## Australian Technology Park Redevelopment– SSDA7317 - Response to Public Submissions

Skylight Analysis - 24 counted along Henderson Road

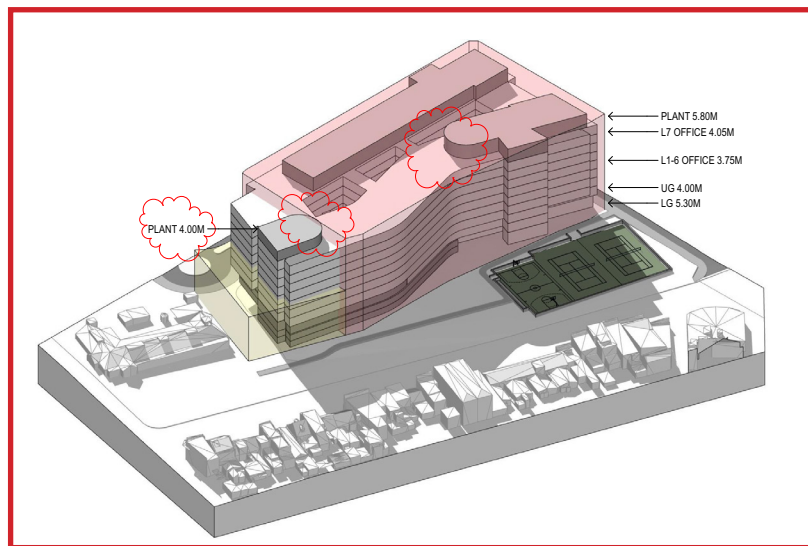
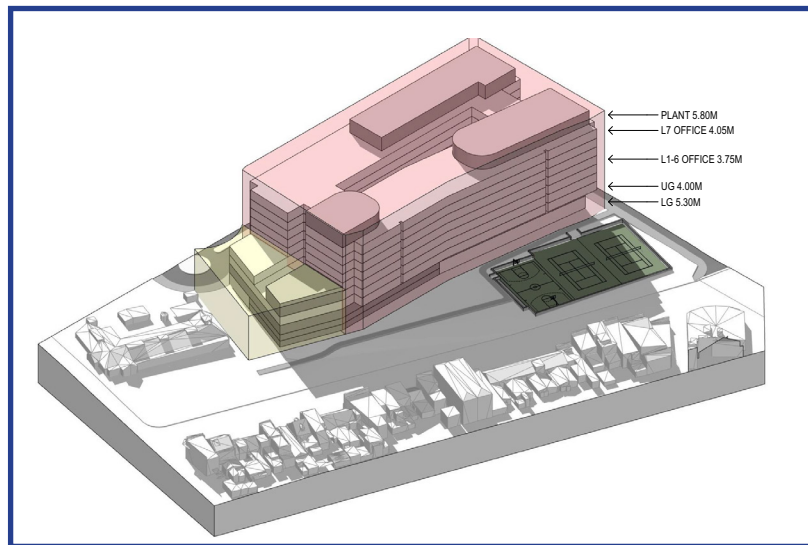
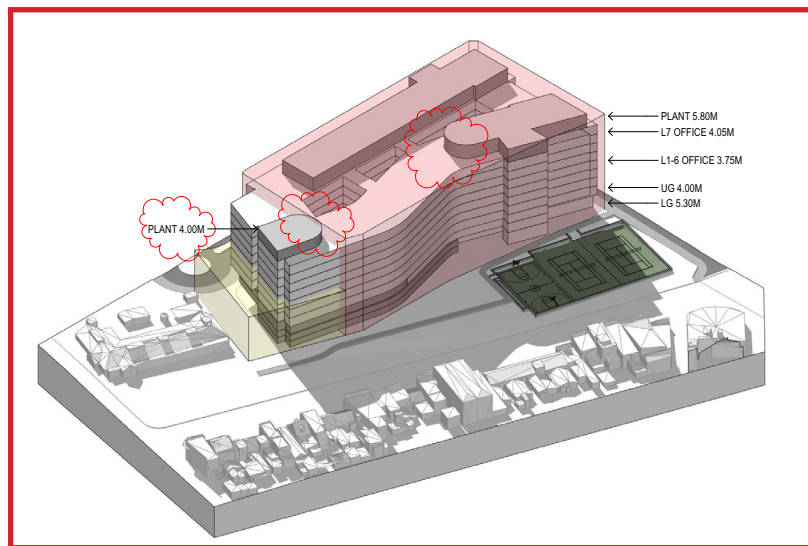
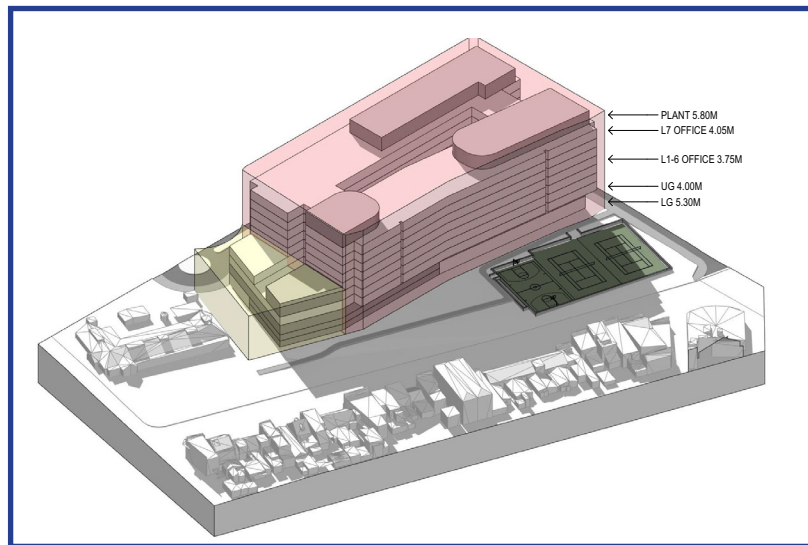
1	The submission to the residents of Henderson Road is offensive and inaccurate. The submission notes that there will be overshadowing but says that they are already overshadowed by trees so it doesn't matter. To dismiss these local residents without any consultation is offensive. To claim that the overshadowing is acceptable for such as a large development is also offensive. The building should be designed to minimise overshadowing.	As above, refer to the expanded solar access and overshadowing study provided at <b>Appendix C</b> and further discussed within the Response to Submissions Report. The proposal does not unreasonably impact on Henderson Road dwellings adjacent to the south of the site. This study does not factor any shadowing by existing mature trees within the street.
1	If the floor area was reduced then the shadow footprint would be reduced. At present the Alexandria Child Care Centre will be totally overshadowed at the equinox, and the Sunbeam Preschool will be partially overshadowed at the winter solstice.	Refer to the expanded solar access and overshadowing study provided at <b>Appendix C</b> and further discussed within the Response to Submissions Report. The surrounding child care centres are not unreasonably impacted by the proposal. In particular, the Alexandria childcare centre is mostly impacted by the existing Channel 7 building, with only a minor increase by the proposal limited to mid-winter. The Sunbeam Preschool is also not affected by the proposal until 3pm.

1	The design of the building has made no attempt to shape the building to eliminate overshadowing to the south, to both windows and skylights. With such a large building over three sites, the building could easily be built higher to the north and lower to the south which would achieve the same outcomes without the overshadowing issue.	Refer above. CBA has a need for large, common floorplates which encourage collaborative and innovative workspaces. Taller structures, even within the northern part of Building 1, would result in more pronounced impacts on the residential dwellings to the south. Refer to the expanded solar study and overshadowing study provided within <b>Appendix C</b> , which provides elevational analysis of the amount of sunlight to each affected dwelling along Henderson Road, including considering skylights.

Number of times raised in Submissions	Item Raised	Proponent's Response
1	As the owner and resident of one of the terrace houses located immediately opposite the development, I am extremely concerned due to the overshadowing that will occur from the development during the winter months. The shadow diagrams to the Henderson Road elevation clearly show the level of impact that will be caused to facing properties between the hours of 11am-3pm during the winter months and the vegetation along Henderson Road.	Refer above. The vast majority of overshadowing occurs with the allowable controls. The proposal results in a balanced overshadowing impact due to the stepped in façade fronting Henderson Road. Refer to further comments and justification provided within the Response to Submissions Report and within the expanded solar access and overshadowing study provided within <b>Appendix C</b> .
1	Building 2 obscures the focal point of ATP which is the draw card feature of the park, the iconic heritage locomotive sheds. I would strongly recommend a building with a smaller footprint so that it does not obscure and loom over the sheds.	Despite the proposed buildings, the Locomotive Workshops will still be visible from a variety of vantage points both from within and from outside of ATP. It is noted that these direct views will be reduced but this is a necessary outcome to achieve development within the existing underutilised lots and to achieve the long-term vision for ATP as a technology hub. Importantly, the proposal maintains views of the Locomotive Workshops through the Entry Gardens from Redfern Station, and from the railway line itself together with the northern Carriageworks precinct. These views are considered to be of greater importance as they strengthen the significance of the retained Workshops in context of the surrounding active and historical railway uses in the precinct.

**Figure 28 –** Childcare centre shadow analysis – 9 am  
*Source: Source: FJMT + Sissons*

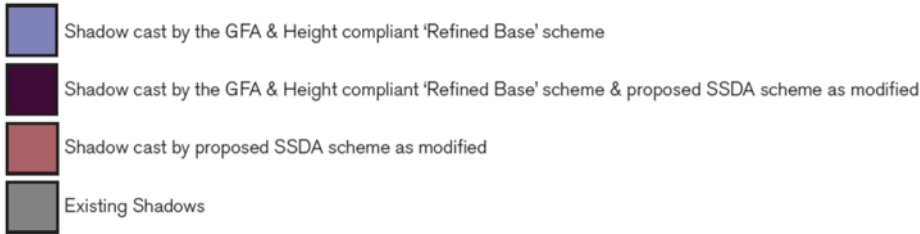
Number of times raised in Submissions	Item Raised	Proponent's Response
		height controls for the site (being 8 storeys, as opposed to part 9 and part 11 storeys as allowed).
<b>Overshadowing and Visual Impact</b>		
19	The size and mass of Building 1 will restrict all direct sunlight in the morning for the Child Care Centre	Refer to the expanded solar access and overshadowing study provided at <b>Appendix C</b> and further discussed within the Response to Submissions Report. The proposal results in negligible overshadowing impacts on the adjoining childcare centre.
17	The size and mass of Building 1 will restrict all direct sunlight in the morning for the residents on Alexander Street	Limited overshadowing will only occur between 9m and 10am during winter solstice for a small number of dwellings along Alexander Street. There are no overshadowing impacts to dwellings in Alexander Street beyond 10am.
